Planning Application Ref: A/76/20/PL

Location: Land at Dappers Lane, Angmering

Description of works: 84 No. dwellings, public open space, play areas, associated infrastructure & landscaping. This application affects a Right of Way.

Mark Warwick
Tree Officer / Parks and Greenspace Team

Planning Layout - 84 Units

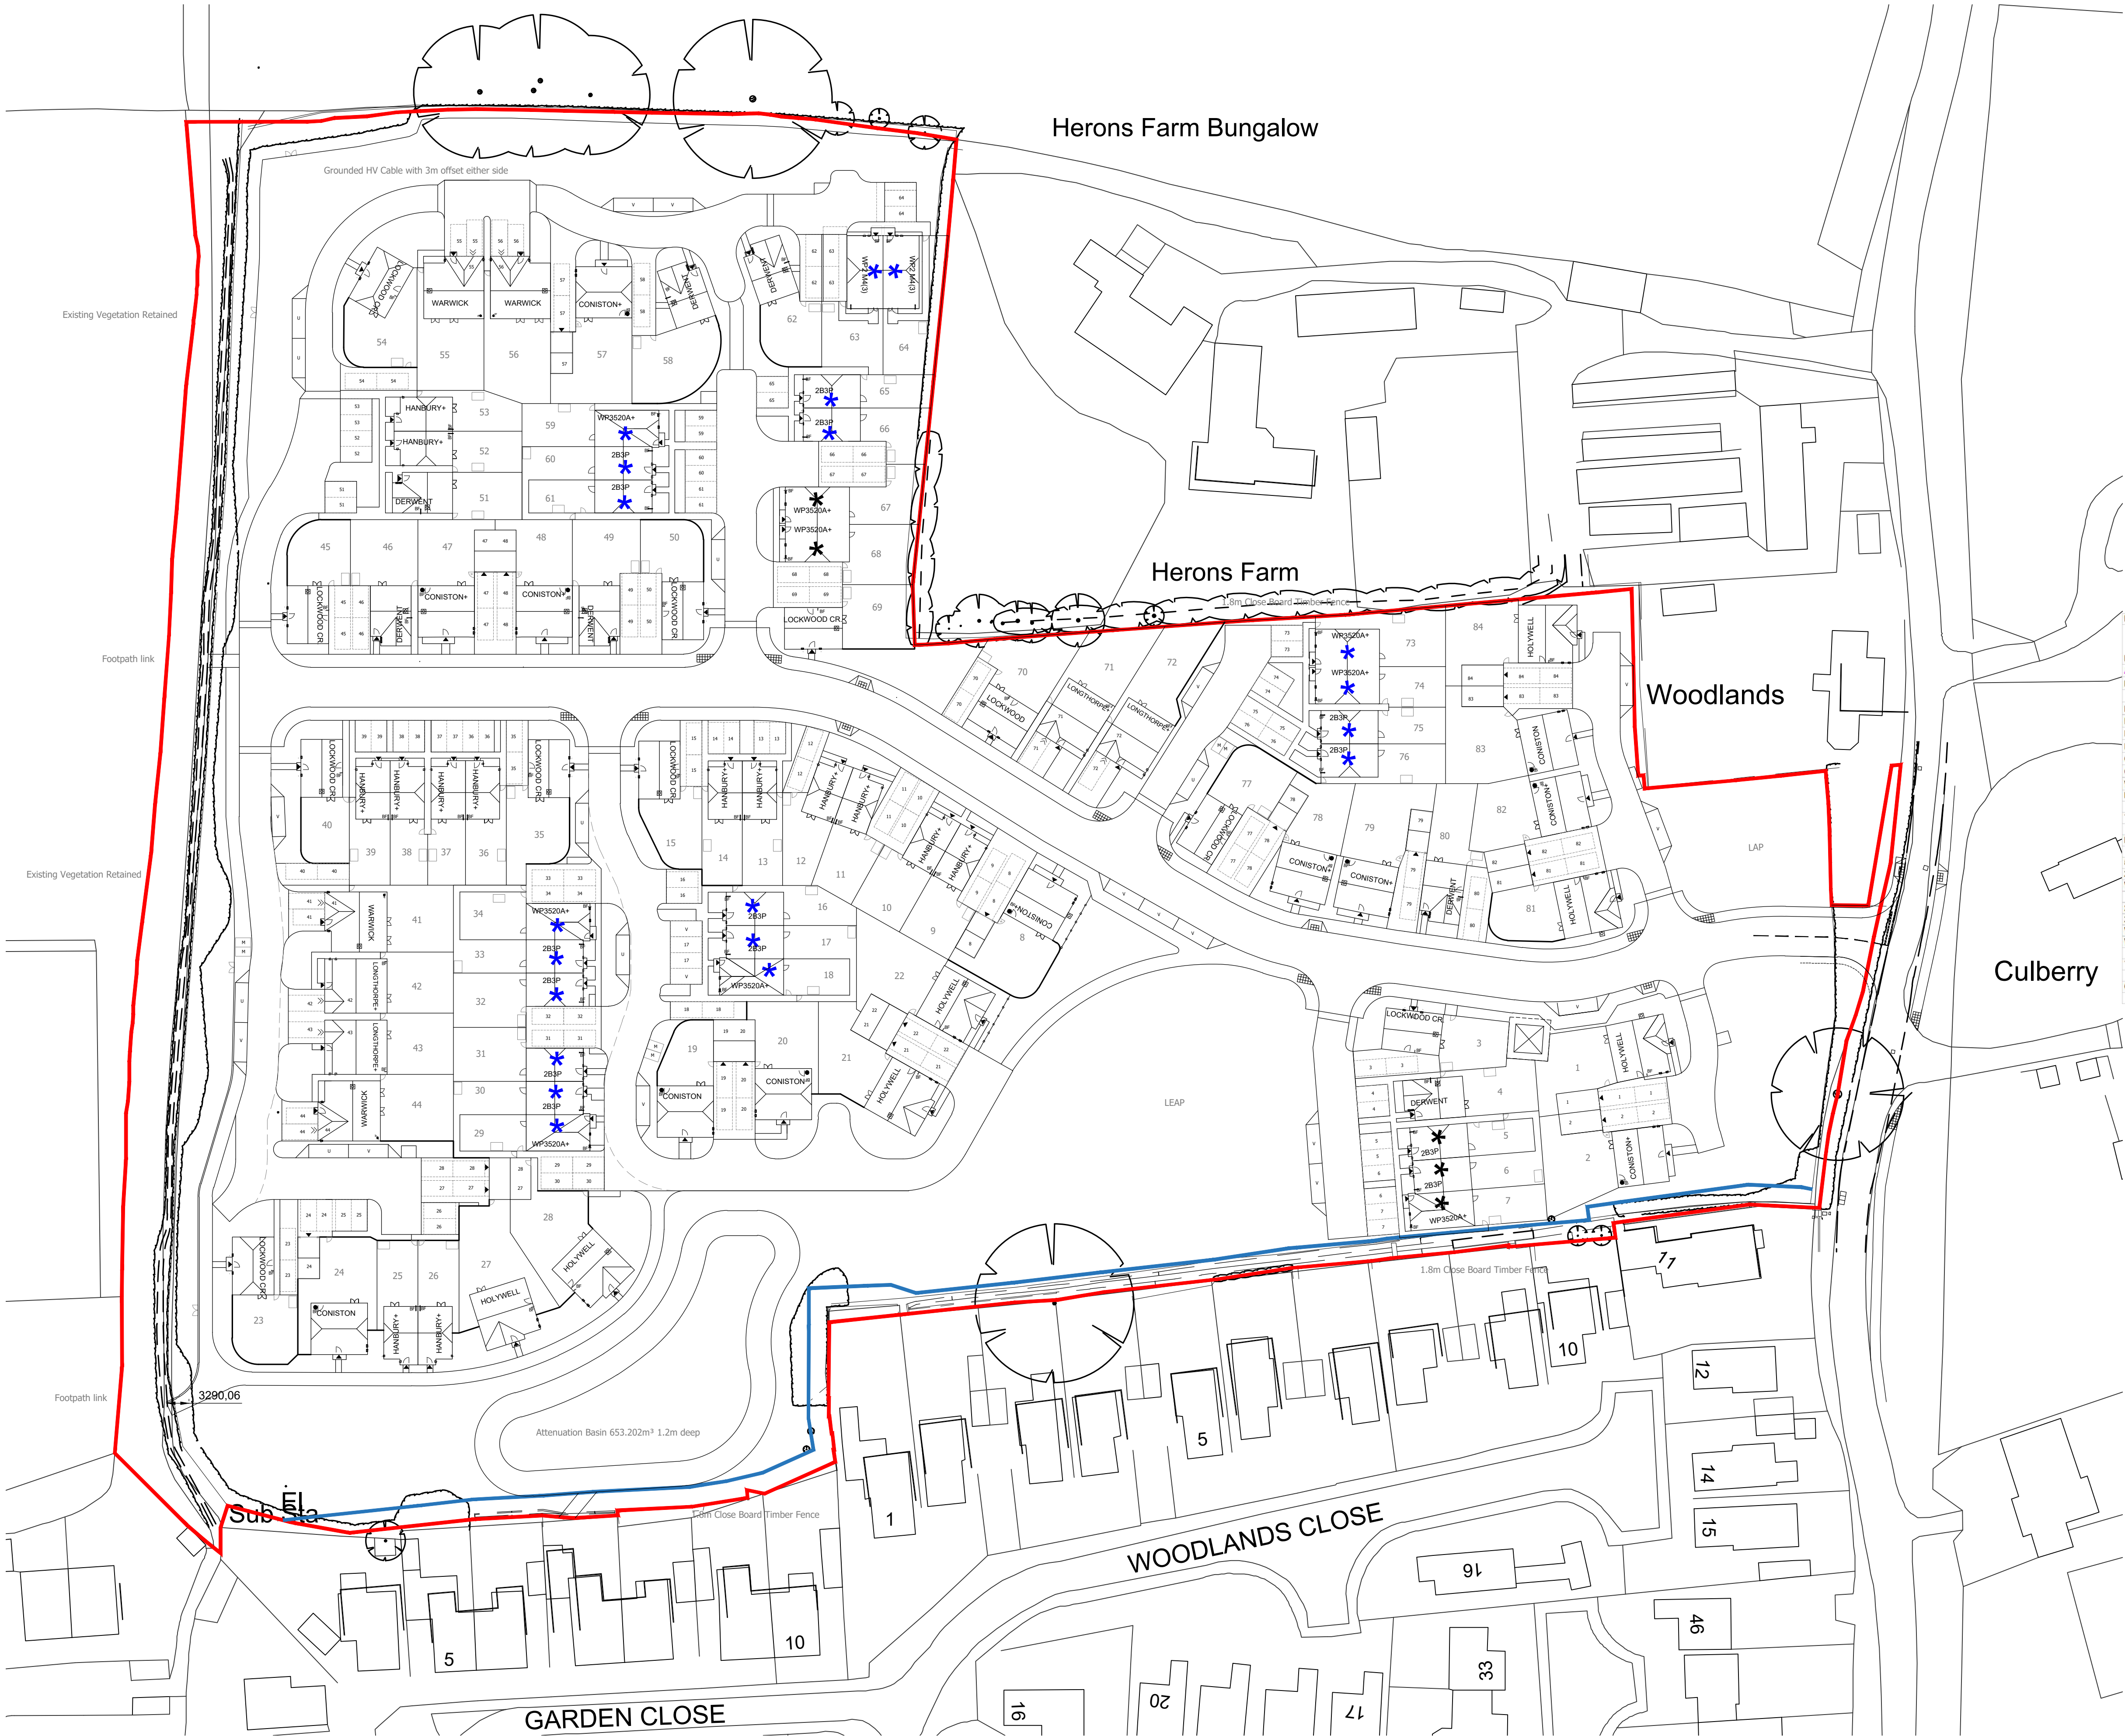
- We have yet to see a site layout with trees (root protection areas and existing crown spread such as provided on the Tree Constraints Plan) accurately imposed over the same, such that we cannot confidently assess how they relate to this proposal. The submitted planning layout (dwg.no. A77-PL-01, Rev A, Nov.'19) appears broadly supportable but with the following item of obvious concern:

- Plot numbers 67-72 are in close proximity to tall, off-site poplar trees. Those tree types have an inherent tendency to form extensive root systems and heavily influence ground conditions, are vulnerable to limb/branch breakage during severe weather events and have relatively low decay resistance. From the Tree Survey provided, it is reasonable to conclude these examples retain high growth potential. Although undoubtedly of landscape value and so can add value to the development (especially if not obscured by built form), they need to be given far more space to flourish and be in harmony with such a change in land use. I expect most occupiers of those plots would perceive significant threat from such trees and limit their enjoyment of rear gardens. I propose those plots be abandoned and units assimilated elsewhere in the scheme, giving the majority of that space over to soft landscape provision although not at the expense of other important buffer zones/open space which currently provide connectivity with the surrounding area. Of special interest is the protected woodland to the north of the site and the 'green corridors' that flow out from that – which must be maintained.

- The principle of development as described is certainly achievable without undue detriment to retained on and off-site trees, although we are yet to have sight of the necessary arboricultural report and plans to demonstrate this has been properly considered.
- The current layout is broadly supportable in arboricultural terms although there is a significant area of concern around plots 67-72 that needs to be revisited before I can support it.

1. In the event that a RPA of any tree which is proposed for retention overlaps the development then BS5837:2012 requires that the Detailed Planning Application is accompanied by an Arboricultural Method Statement (AMS) and also most importantly a Tree Protection Plan – to both describe and illustrate the mitigation measures which are to be employed to ensure that the trees survive without detriment to their vigour and vitality and are given adequate protection both above and below ground.
2. As it stands, I am unable to lend this scheme my support and so register an **OBJECTION**, although expect that to be easily overcome with a slight but important amendment to the layout and with the ongoing support of their project arboriculturist.
